From: Liz Annalls 
Sent: 24 September 2020 09:30
To: Planning.Responses <Planning.Responses@arun.gov.uk>
Subject: RE: Planning Consultation on: FG/111/20/DOC

Application No: FG/111/20/DOC
Site Address: 58 Ferringham House Ferringham Lane Ferring BN12 5LU
Description of Works: Approval of details reserved by condition imposed under ref FG/41/20/PL relating to Condition Nos 3 - materials & finishes, 7 - external lighting, 9 - bin enclosure, 10 - energy statement and 17 - landscape plan.

Condition 7 – lighting

Condition 17 – Landscaping

DRAWING TITLE
Overall Site Plan
BUILDING REGS ISSUE

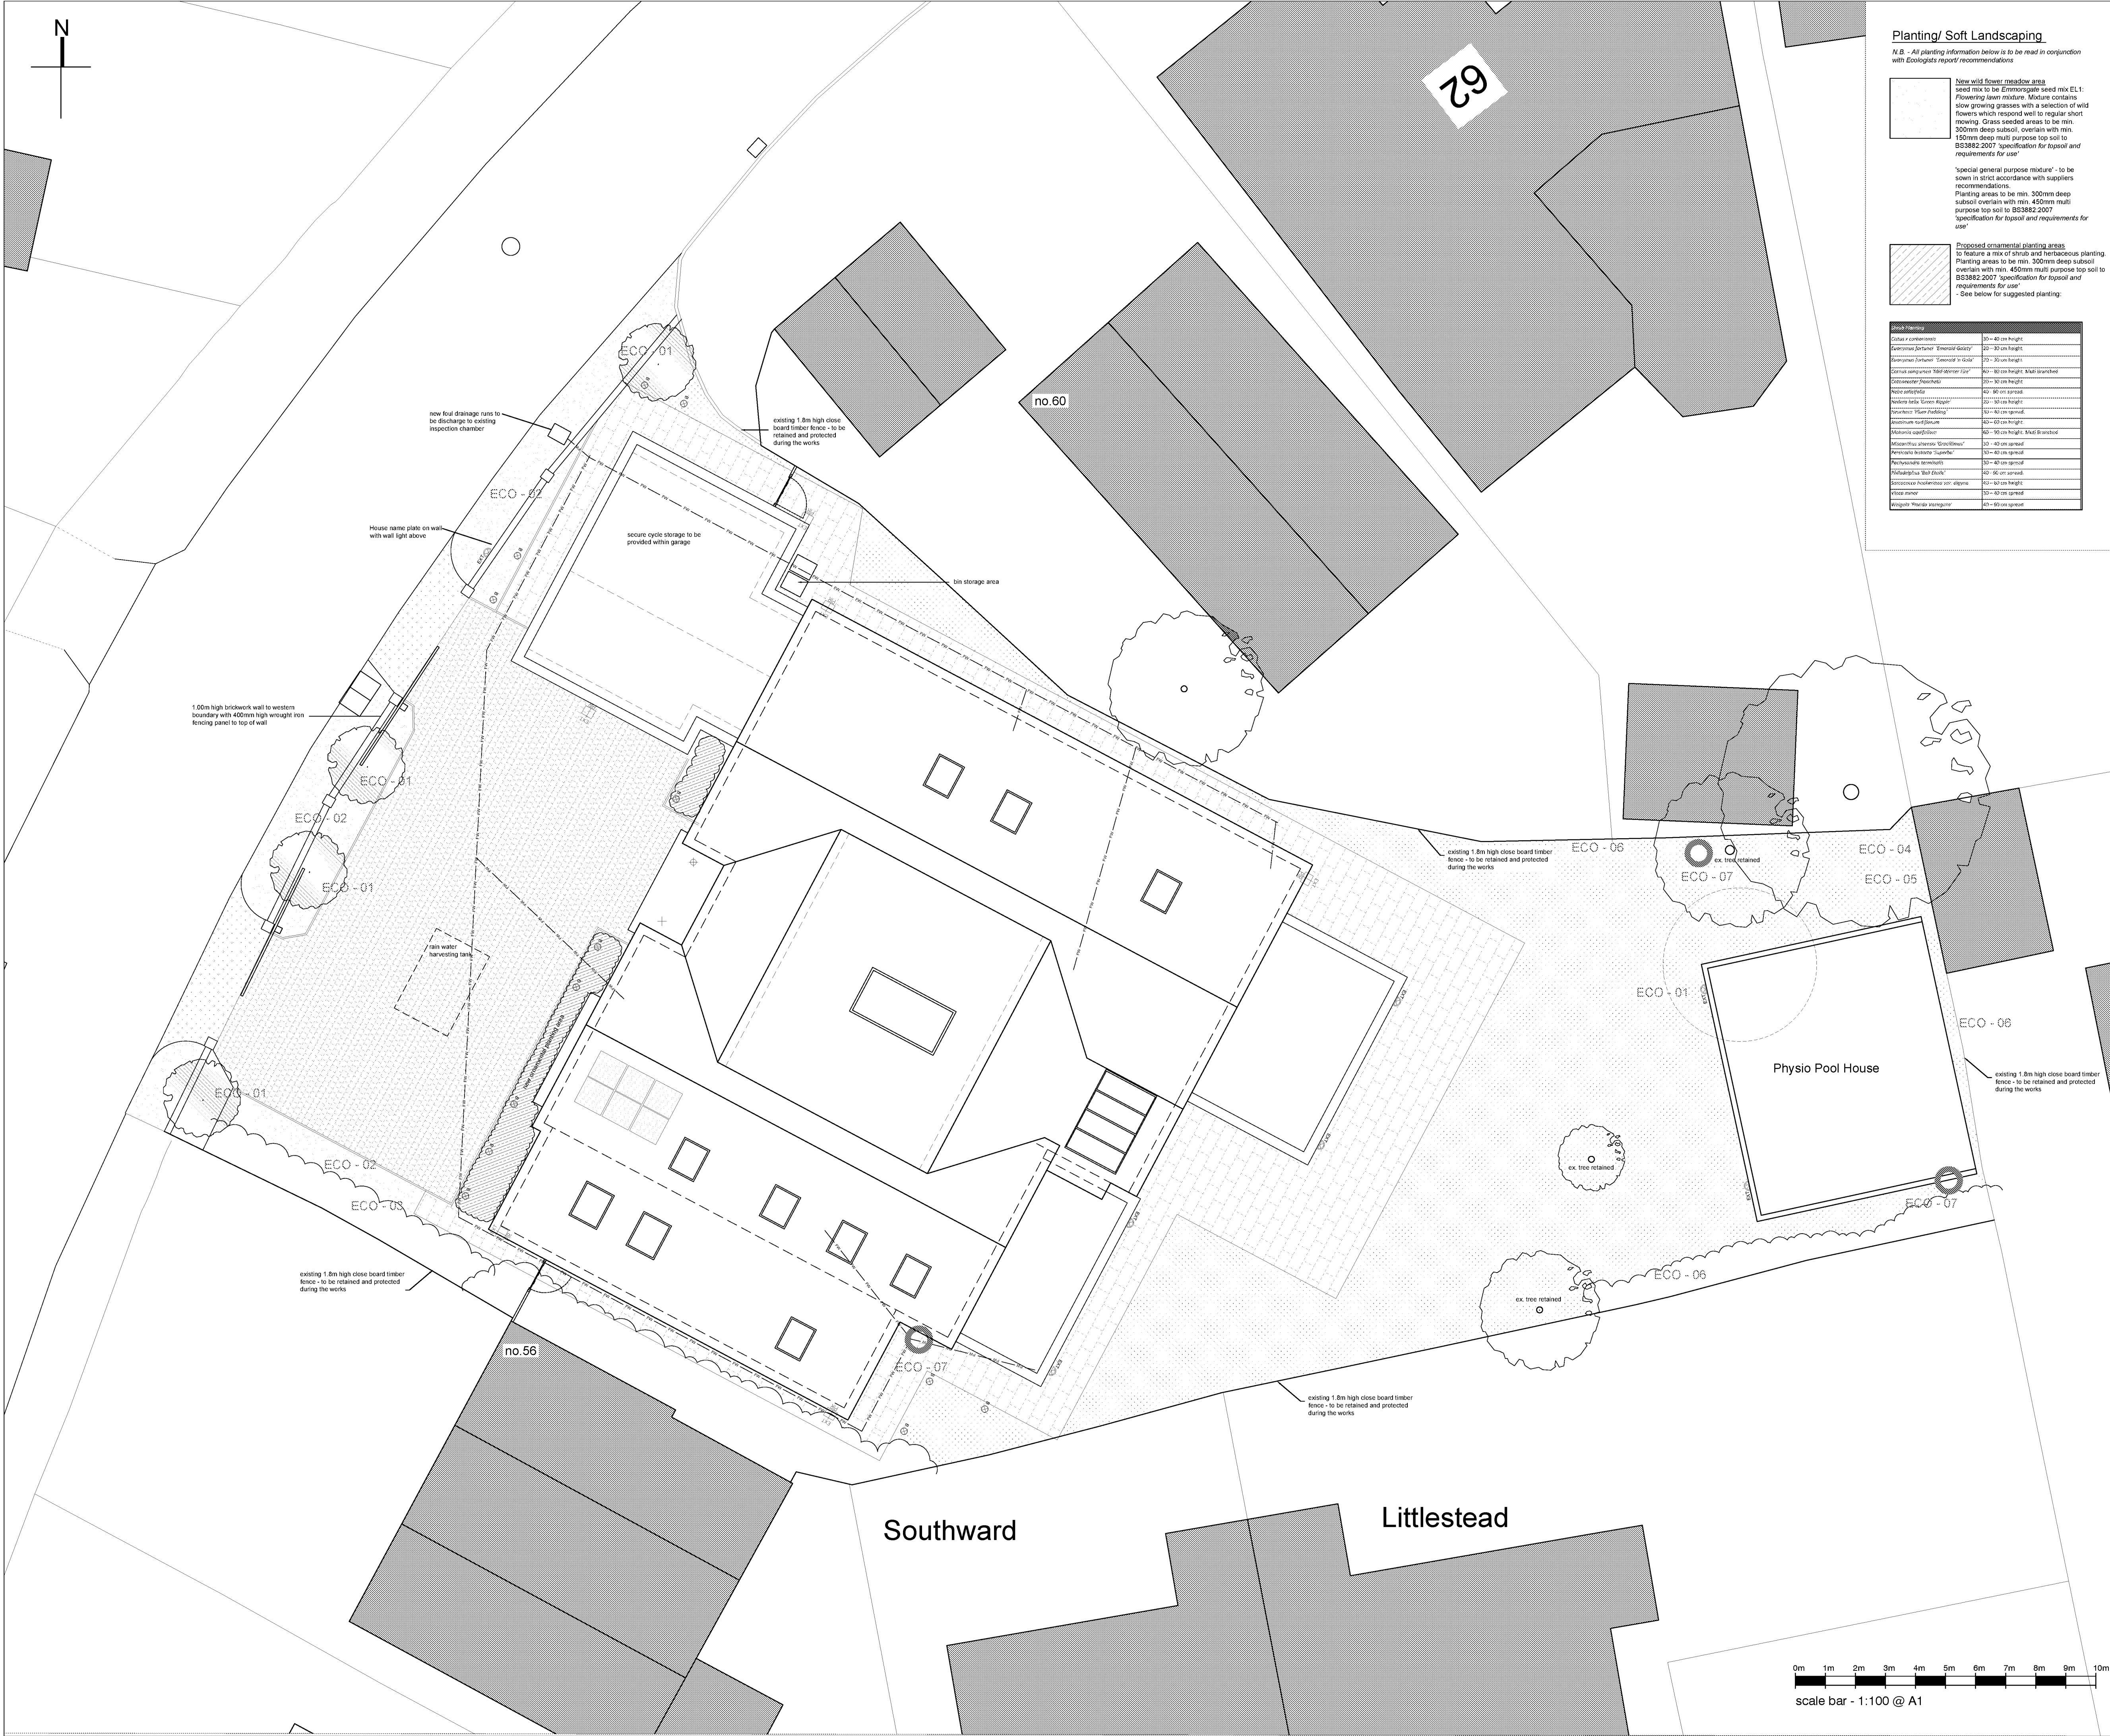
Please can the application provide information about the lighting units which will be used in the scheme. We require that external lighting minimises potential impacts to any bats using the trees, hedgerows and buildings by avoiding unnecessary artificial light spill through the use of directional light sources and shielding.

We are satisfied that the information provided regarding ecological enhancements included within the site plan are suitable for this site.
